From: **Marc Daley** <Marc.Daley@environment.nsw.gov.au>
Date: Tue, Sep 8, 2020 at 11:00 AM
Subject: RE: Moonee SSD 7198
To: Jason Wasiak <jason@jwplanning.com.au>
Cc: Emma Butcher <Emma.Butcher@planning.nsw.gov.au>, Krister Waern
<krister.waern@environment.nsw.gov.au>

From: Jason Wasiak <jason@jwplanning.com.au>
Sent: Monday, 7 September 2020 3:22 PM
To: Marc Daley <Marc.Daley@environment.nsw.gov.au>
Cc: Emma Butcher <Emma.Butcher@planning.nsw.gov.au>; Eric Fuller <e.fuller7@icloud.com>; Kerry Albert <kerry.albert@uniteadvisory.com.au>
Subject: Moonee SSD 7198

Subject: RE: Moonee SSD 7198

Job No: P1002663

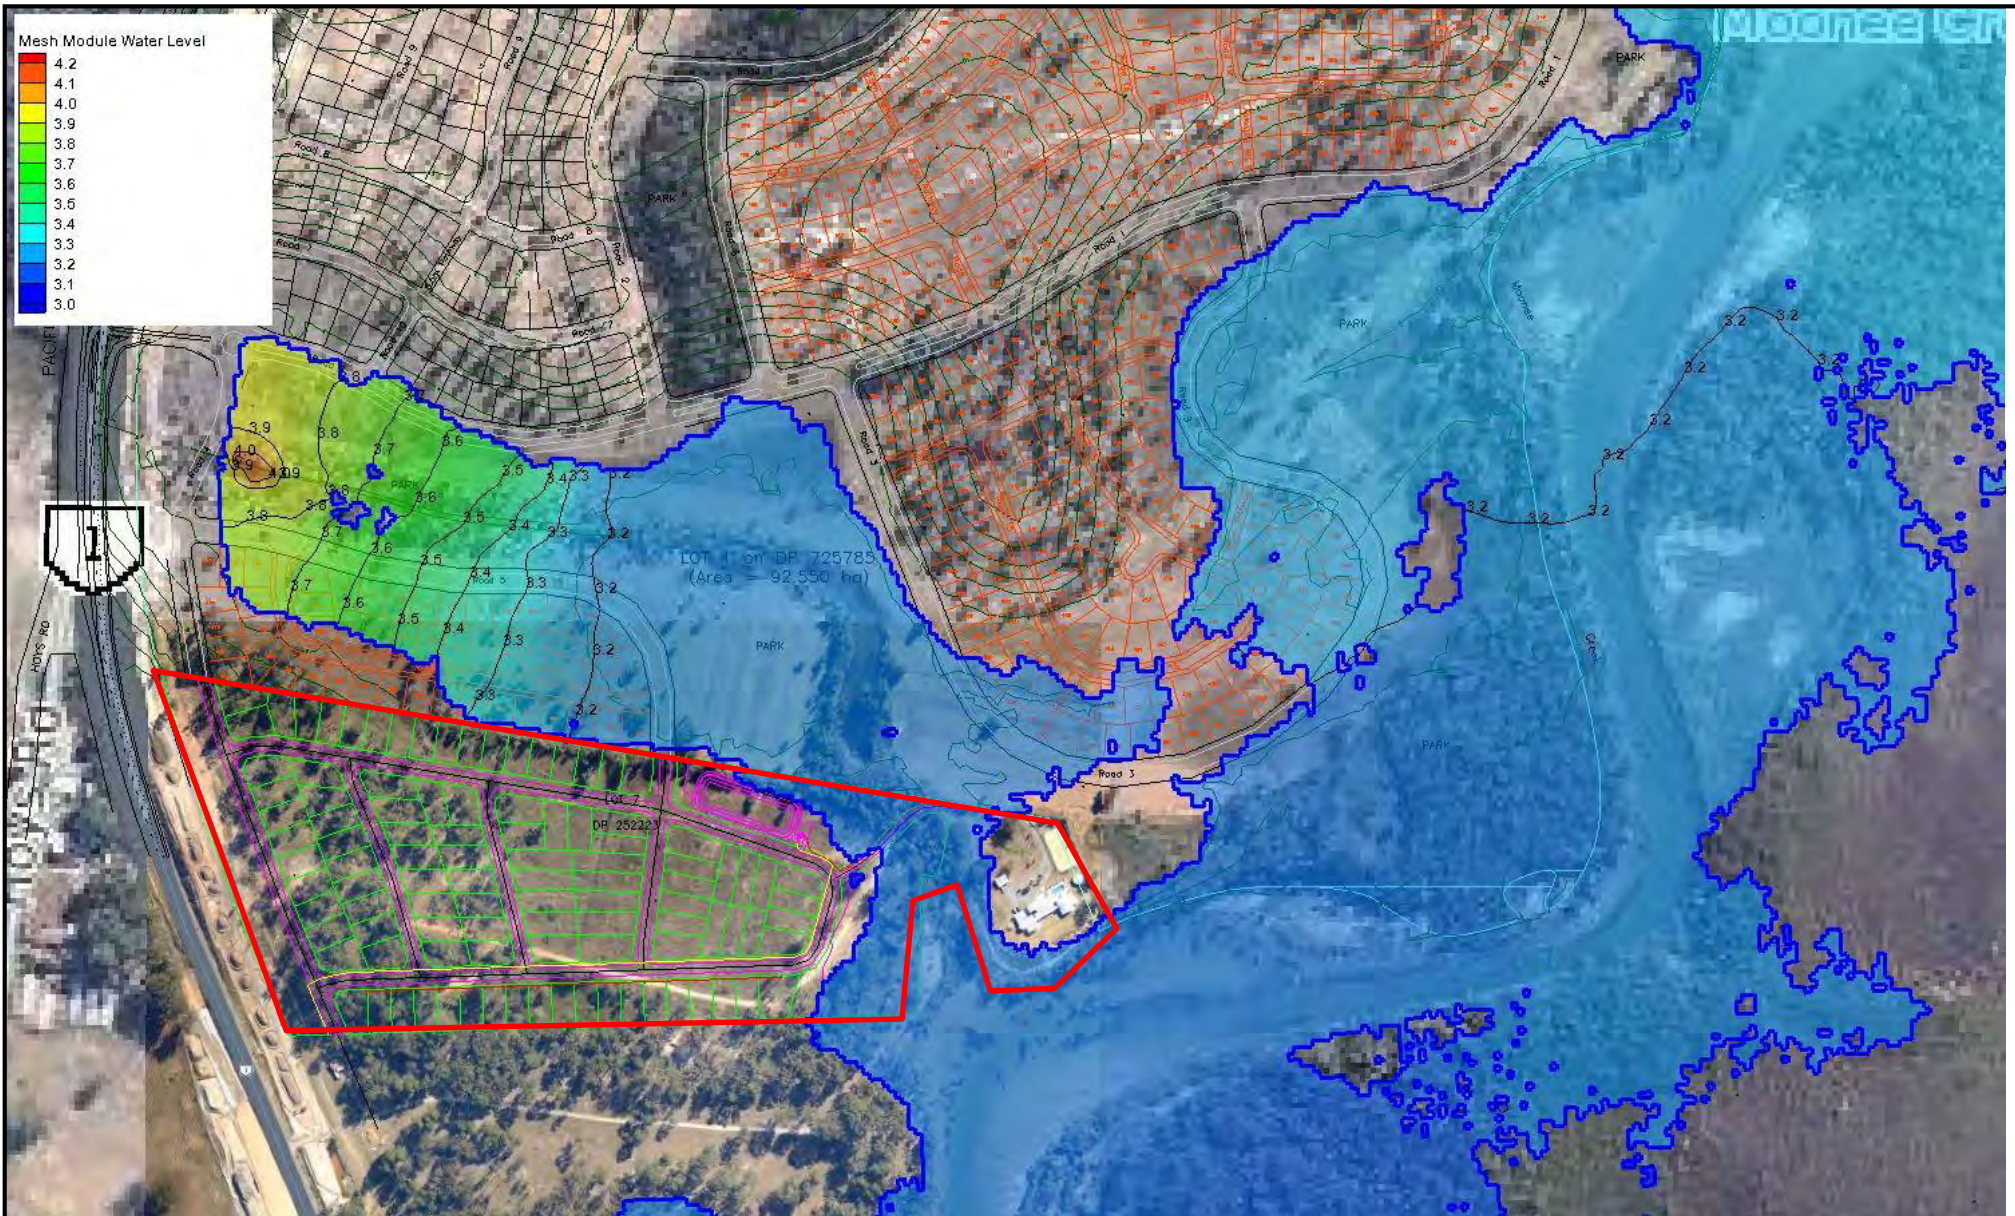
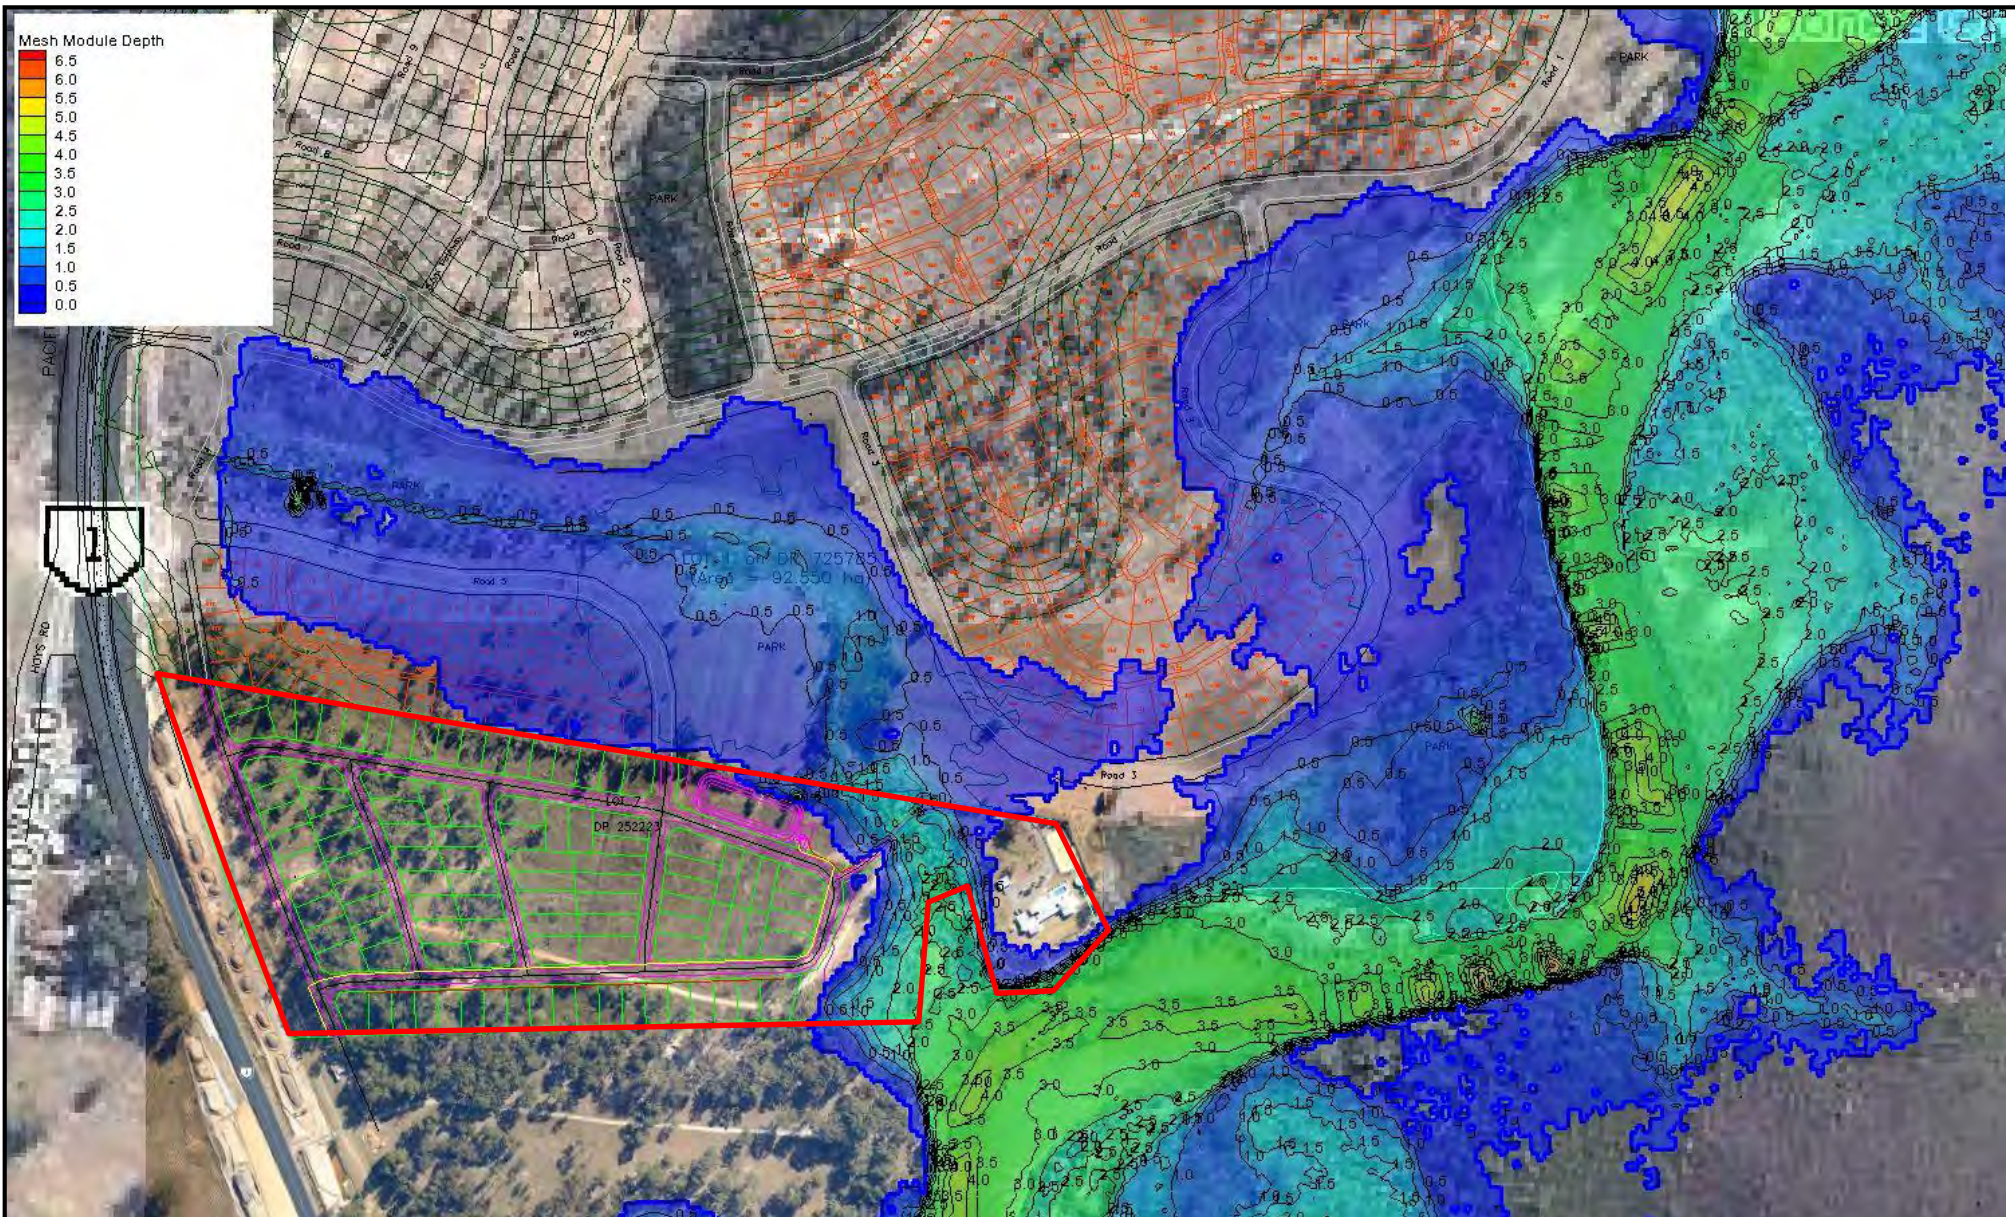
Please note the request wasn't for a 1% AEP flood and 1% AEP ocean water level to occur concurrently, per Jeff's reply. Only that proper consideration has been given to the tidal inundation through the ocean water level component, including the future impacts of projected climate change. From the flood modelling report initially provided, though scenarios 5 and 10 were listed, it wasn't clear how these scenarios were determined and the considerations given in relation to the ocean water boundary.

He is seeking clarification as to whether tidal inundation was included in the flood modelling. He said it was unclear from the data within the Marten's report.

He suggests that normally a 1% ocean water level + Sea Level Rise is factored into modelling, but believes this may not have been necessary if local catchment flooding is equal to or greater than ocean water flood level. Does this make sense to you, and can you please call me to discuss ASAP?

With reference to Section 3.2.3 of our flood assessment report, we have run various flood modelling scenarios. The worst case scenarios (5 and 10 in our report) assessed a 1% AEP flood with a 5% AEP climate change ocean level plus climate change of 0.91m (being 3.01 mAHD).

The BCD request for modelling a 1% ocean level plus 0.91m is contrary to the above. It also differs from the previous advice and discussions that we had with Council and WBM (experts acting on behalf of the Council). We note that applying BCD's request would mean modelling a very rare event, given that the 1% events for the flood and the inundation would need to occur concurrently. I expect this is why the various department guidelines noted above do not require such events to be modelled for design.

In light of the above, our flood assessment is considered satisfactory to assess impacts from tidal inundation and not further modelling is considered necessary.
